From: [Jason Thomas](#)
To: [Watkinson, Gregory](#)
Cc: [Simon Fraylich](#)
Subject: Re: Automatic reply: H08-1097-21 59 High Street Gosberton
Date: 10 December 2021 15:59:43

I have completed my report and am now in the process of signing off. However, a couple of matters have been raised that I would appreciate if could be clarified in writing by yourself, following on from review of the comments submitted by our trees and nature conservation officer.

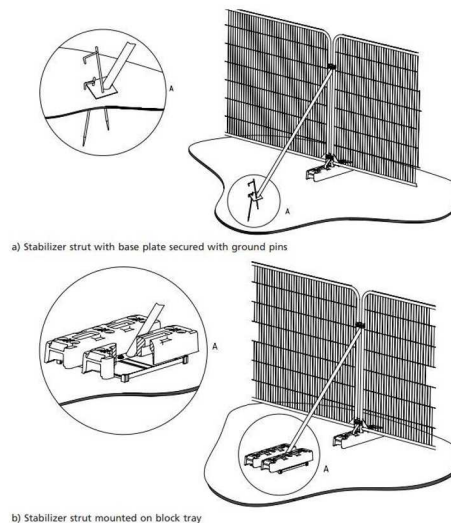
1) In relation to the emplacement of the helas panels around the lime tree after

rather than before site prep, please can you confirm in writing how you will avoid perambulation and any other form of damage to the lime tree prior to the installation of the heras panels.

2) Please can you confirm that as part of you programme of works, any area of previous driveway within the root/spread protection area of the lime tree will be de-compacted prior to the laying of new material in order to allow free flow of gaseous and liquid exchange.

In light of this query and in retrospect we will erect the 'heras' fencing prior to the any work commencing on site.

Yes we will de-compact the area of the drive within the area of protection of the lime prior to any new material being applied t the surface.
